Our ref: DOC20/268731

**Subject: Request for Notice of Exhibition for Chatswood Education Precinct, (SSD 9483)  
(Willoughby City)**

## **Attachment A – Chatswood Education Precinct – SSD 9483 – Biodiversity Development Assessment Report**

EROSION AND SEDIMENT
CONTROL PLAN - CENTENNIAL
AVENUE

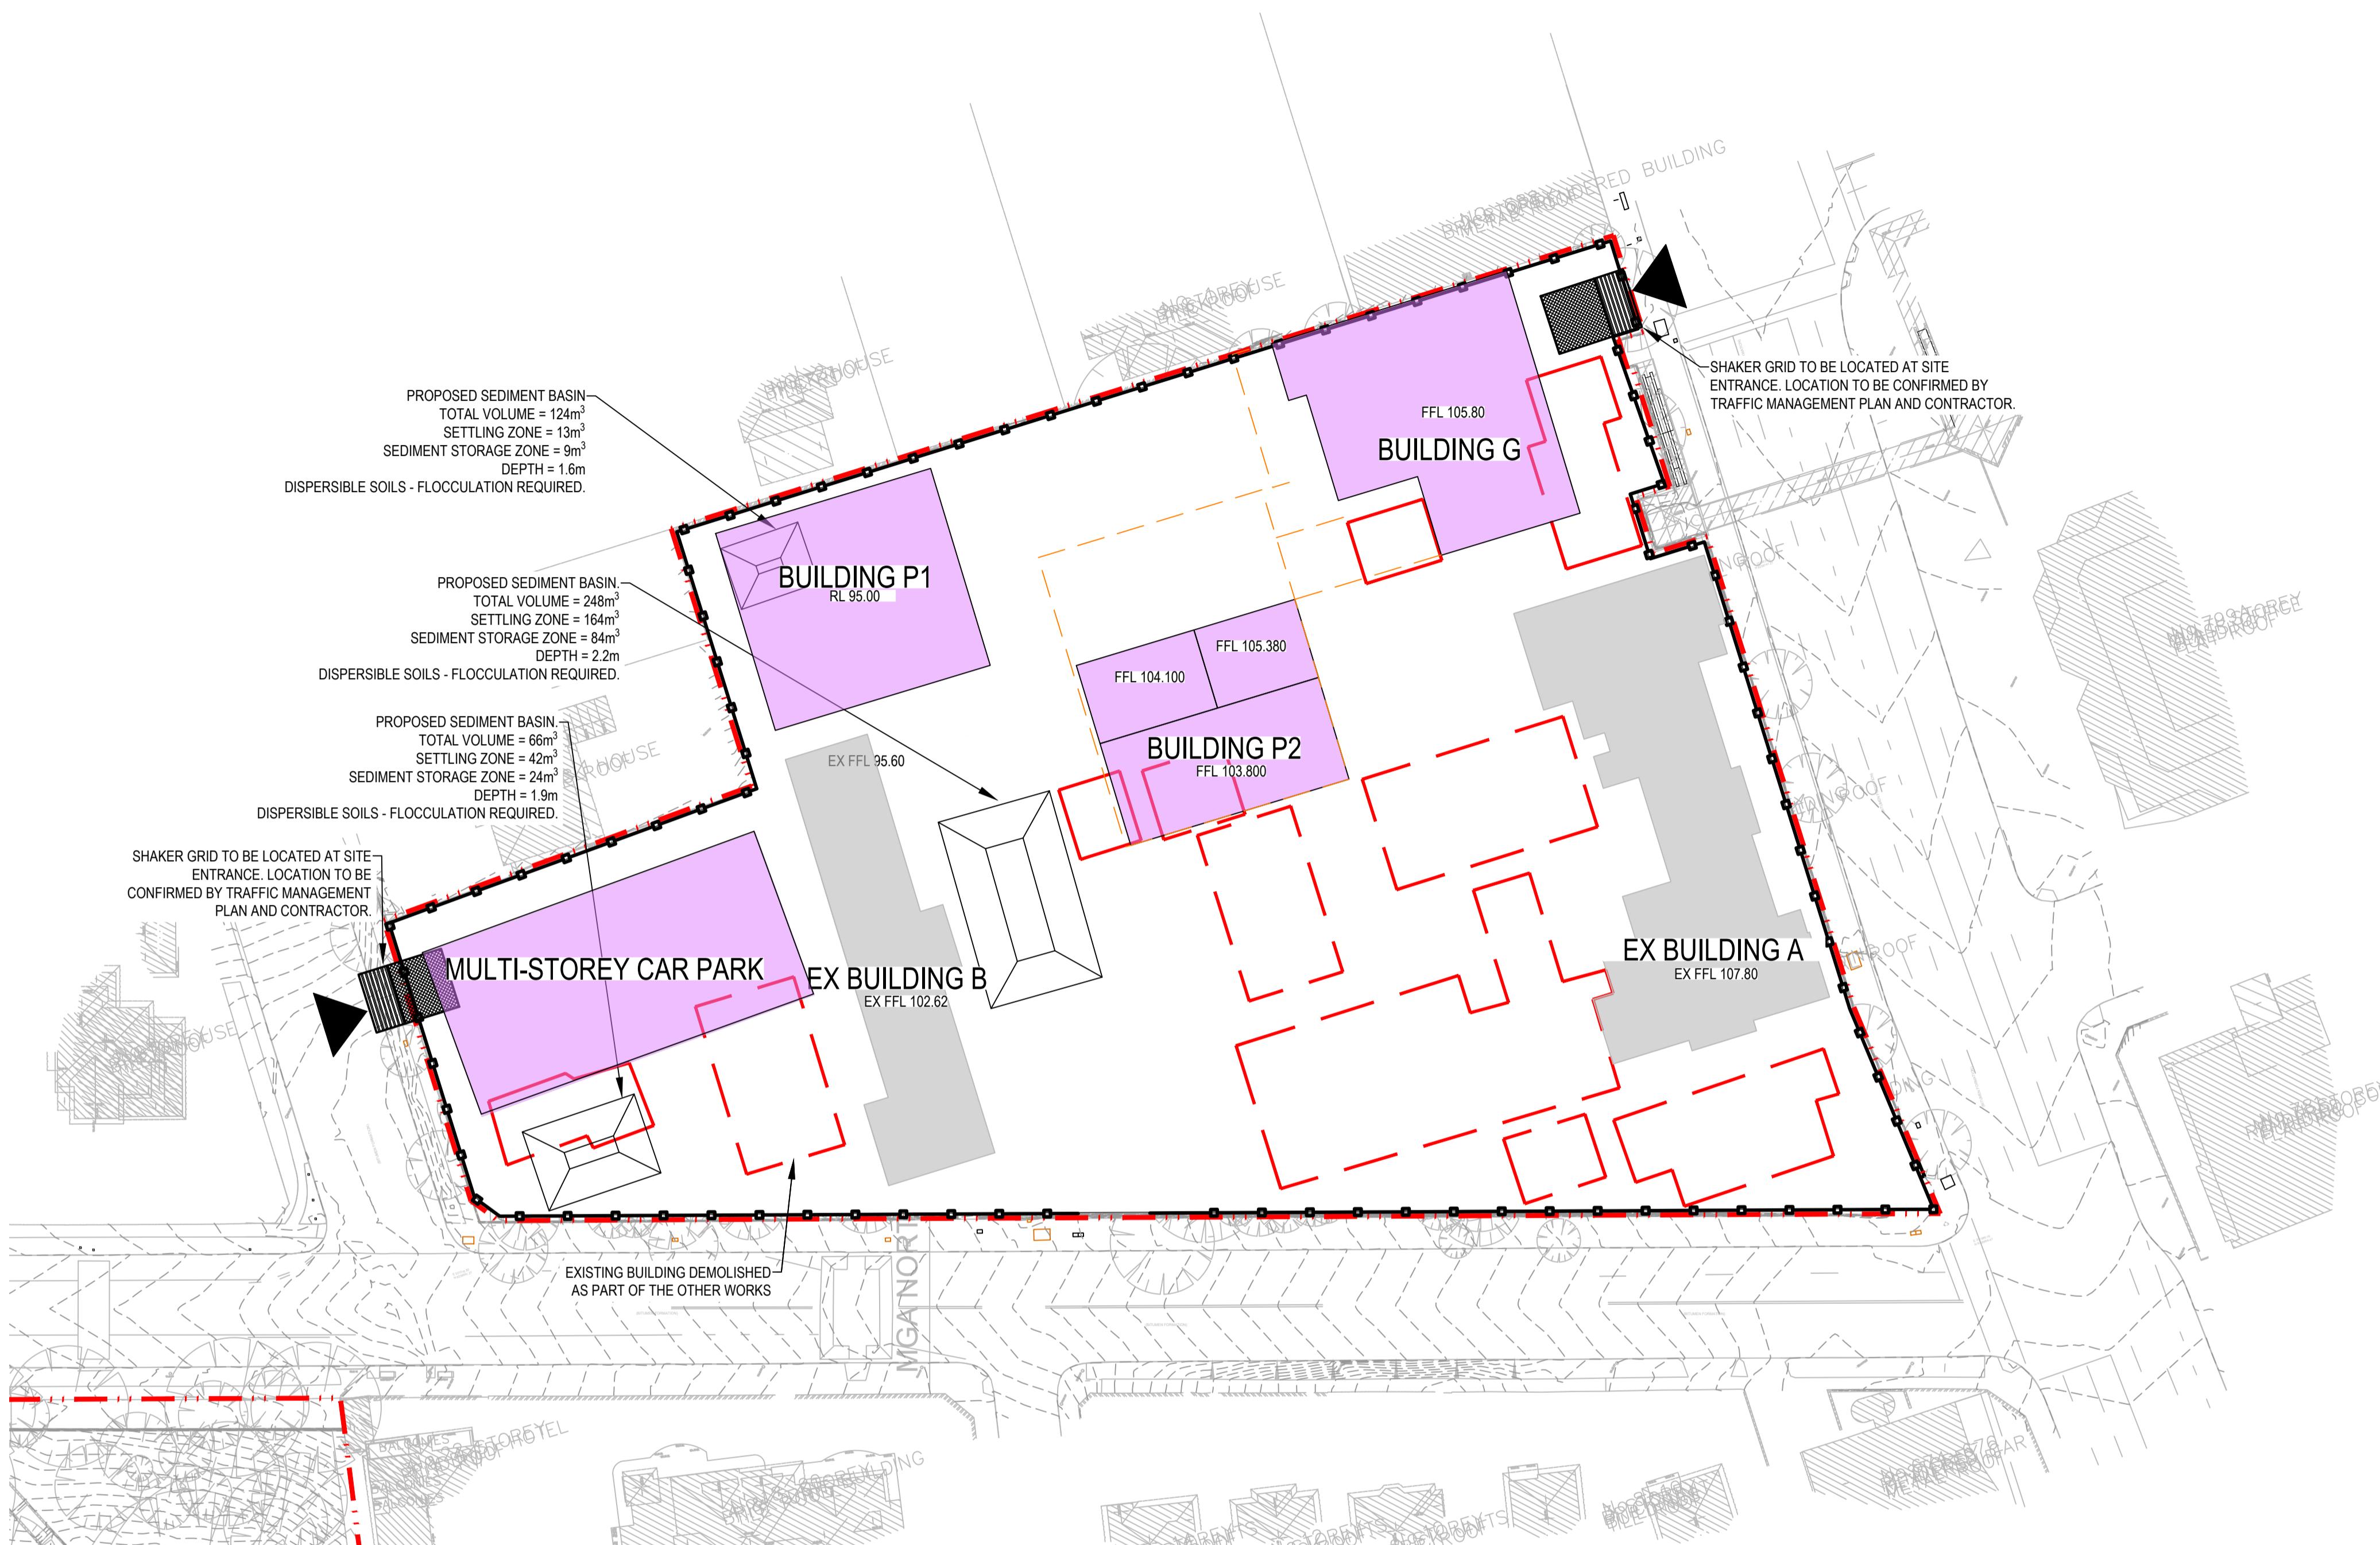
It has not been explained why proposed building T cannot be oriented so that it completely avoids impacting the Blue Gum High Forest. For example, is the same orientation as the existing buildings possible (see civil engineering drawing CI-070-002 Rev. F)?

EES recommends clarification on this matter.
